Development Facilitation Team (DFT) – Review Comments

DRB Project No: PR-2022-007680 Date: 5/24/2023 Agenda Item: #3 Zone Atlas Page: J-13

Application For: SD-2023-00088 – Preliminary/Final Plat (DHO)

**Plat for
Lots 2-A and 3-A,
Subdivision of Lot 13 Navajo Addition
Being Comprised of
Lots 2 and 3,
Subdivision of Lot 13 Navajo Addition
City of Albuquerque
Bernalillo County, New Mexico
March 2023**

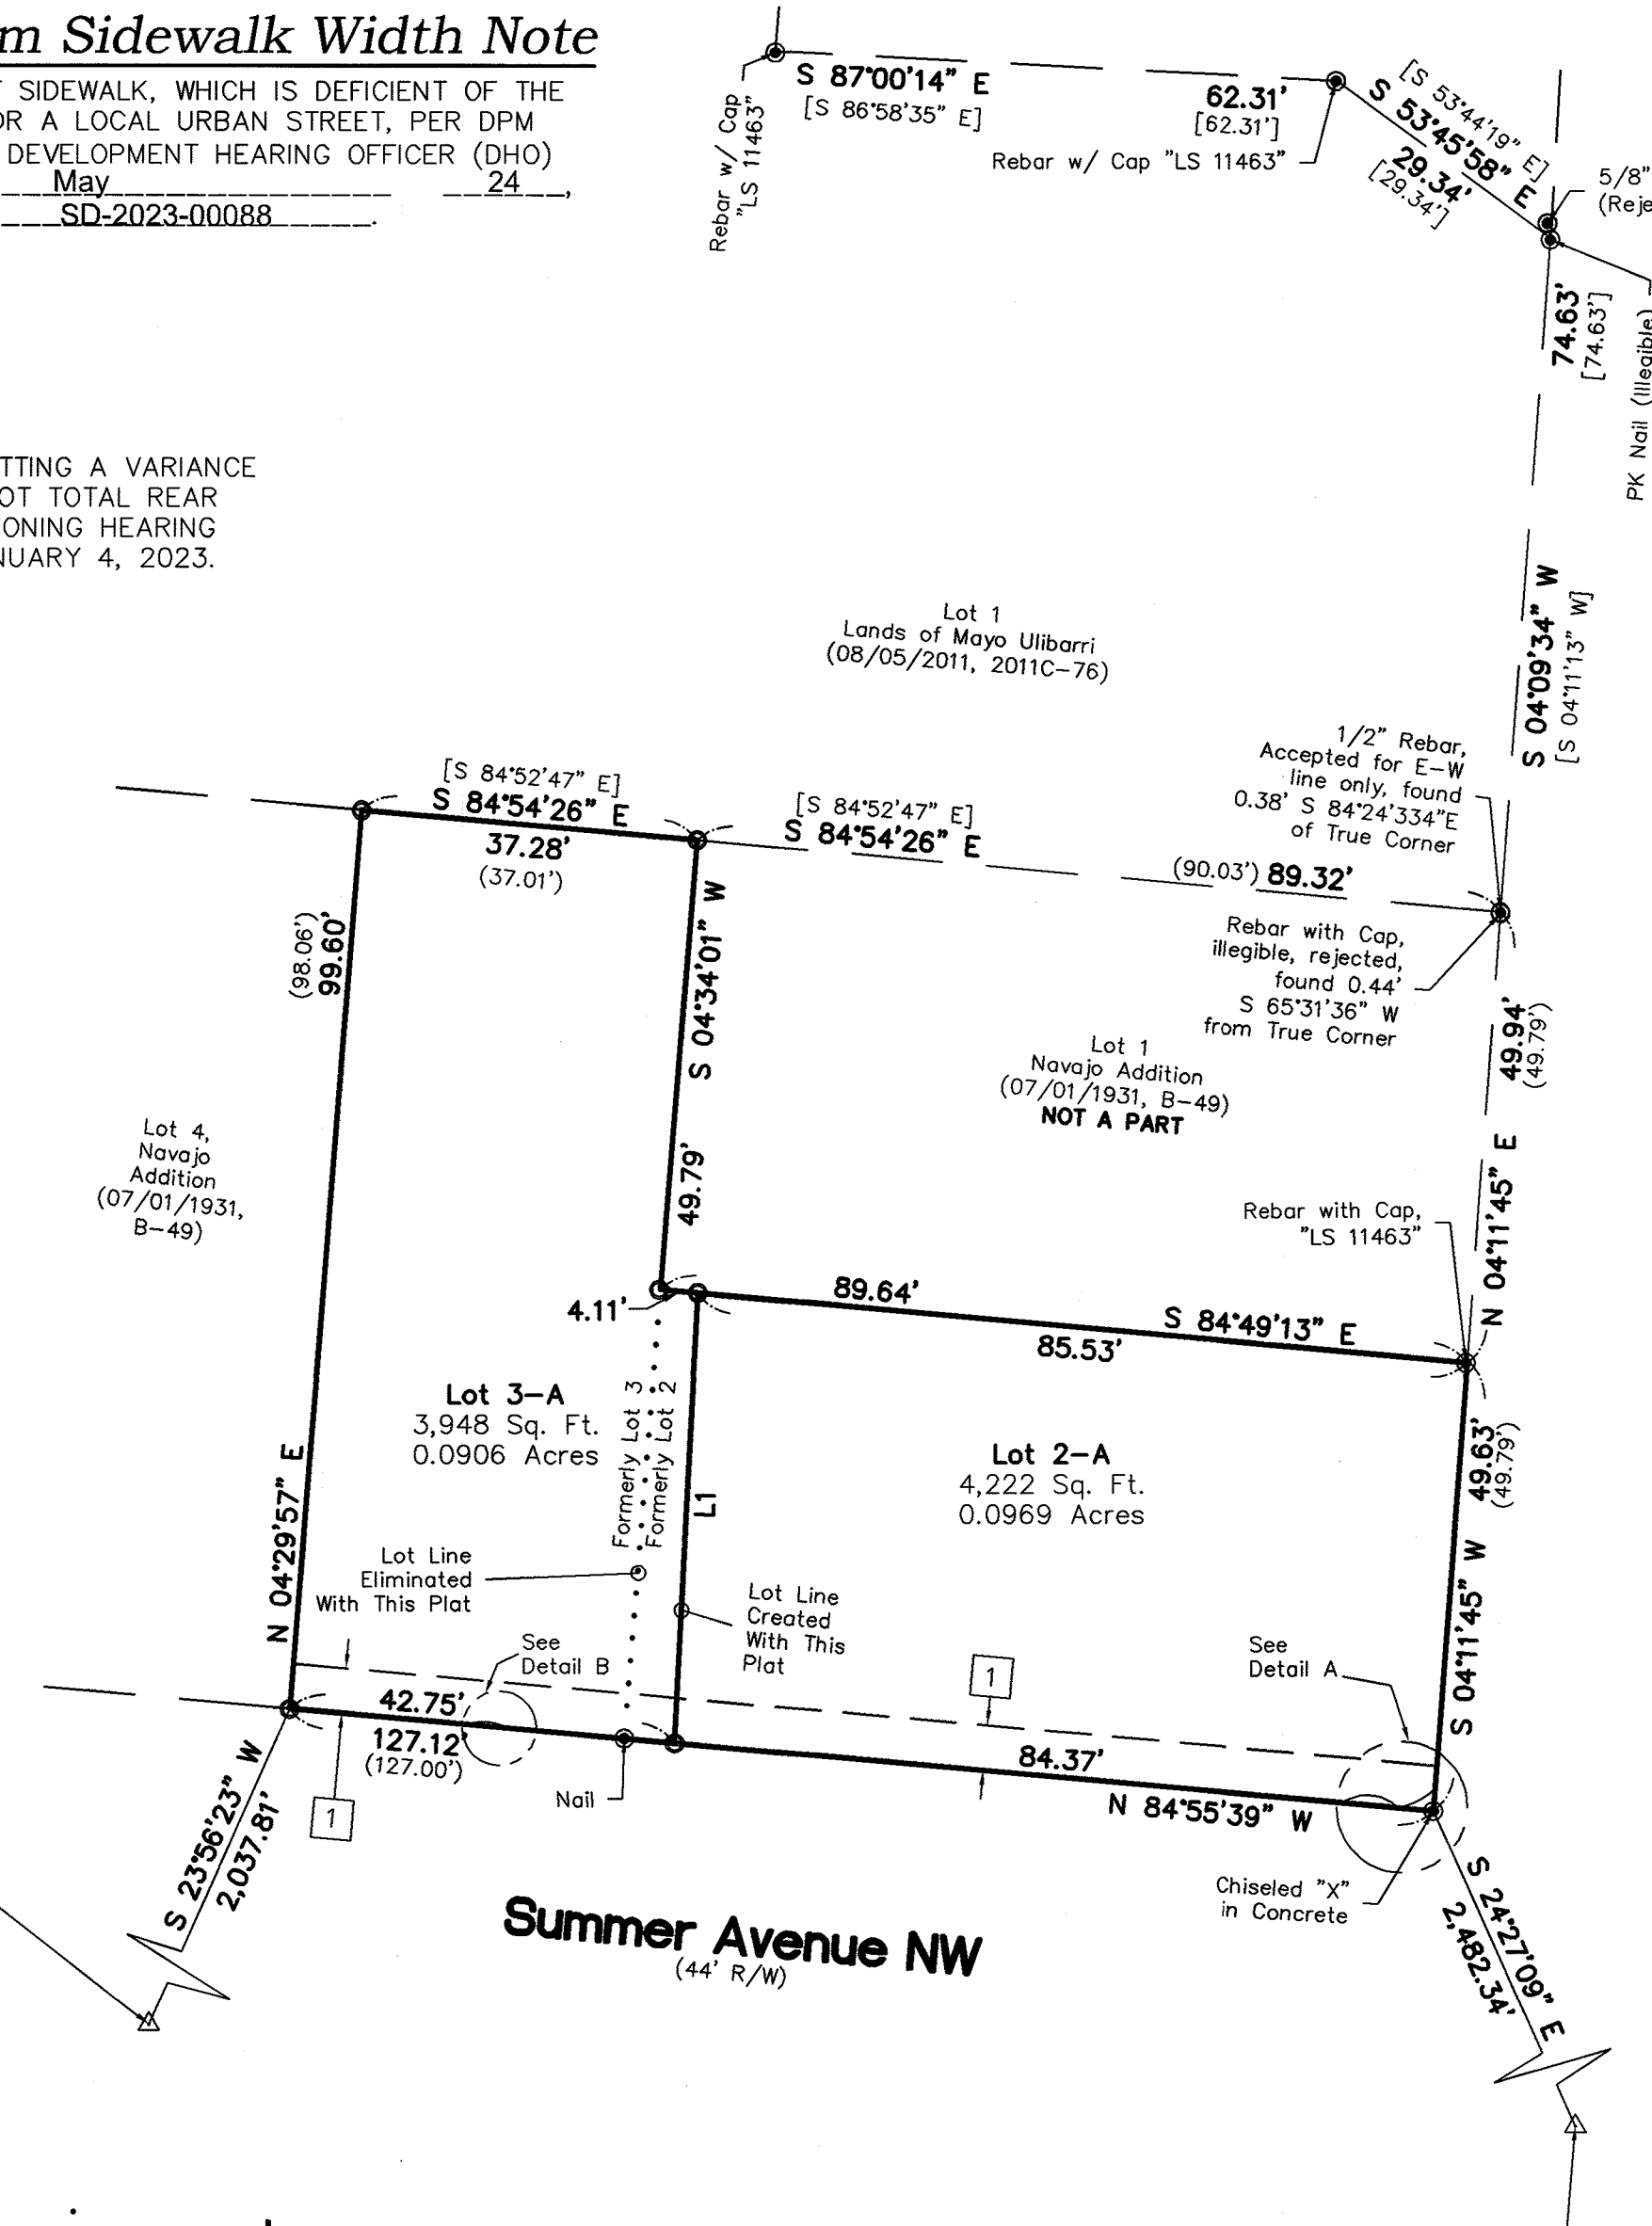
1. No objection to the proposed lot line adjustment.
 - a. However, any necessary sidewalk work would need to ensure the proposed hydrant is not in an ADA path.
